From: system@accelo.com on behalf of [REDACTED]
Sent: Wednesday, 14 March 2018 2:03 PM
To: Tim Green
Subject: Submission Details

Submission for Job: #9007 SSD 6339 MOD 1 - Staged Redevelopment of School Campus (Concept & Stage 1 Research, Performing Arts and Aquatic Centre)
https://majorprojects.accelo.com/?action=view_job&id=9007

Site: #2894 St Catherine's School, Waverley
https://majorprojects.accelo.com/?action=view_site&id=2894

ELEVATIONS - NORTH & WEST

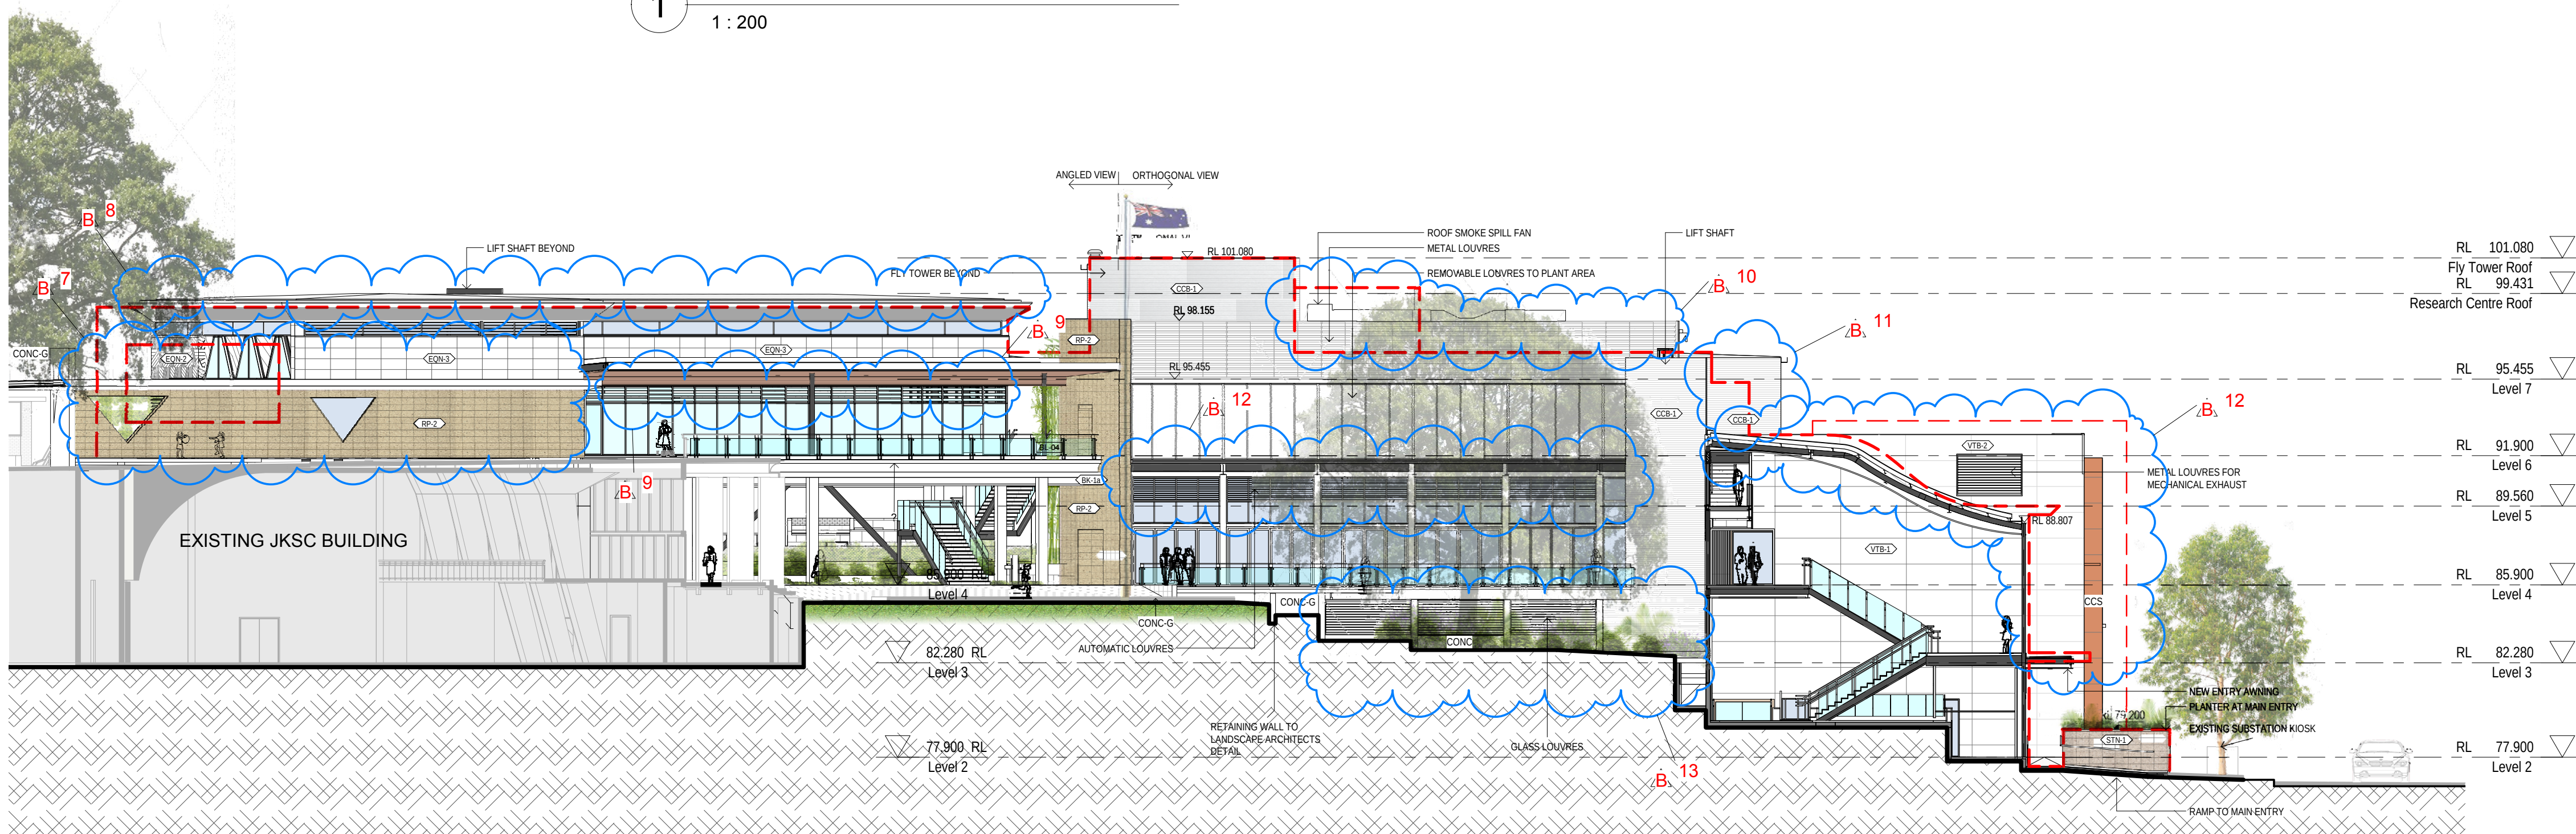
The new facade and height onto Macpherson Street will adversely impact the environment and loom over the street. There should be no increase in height, or the facade's impact on the amenity of the street's users. The relocation of the pedestrian crossing, further from the roundabout significantly impacts people walking along Albion Street, especially those with strollers or who have challenges walking, who already have to walk a long way down Macpherson Street to use the crossing (or run the gauntlet of crossing near the roundabout, already a danger due to impatient drivers at this very busy intersection, many of them dropping off at the school)
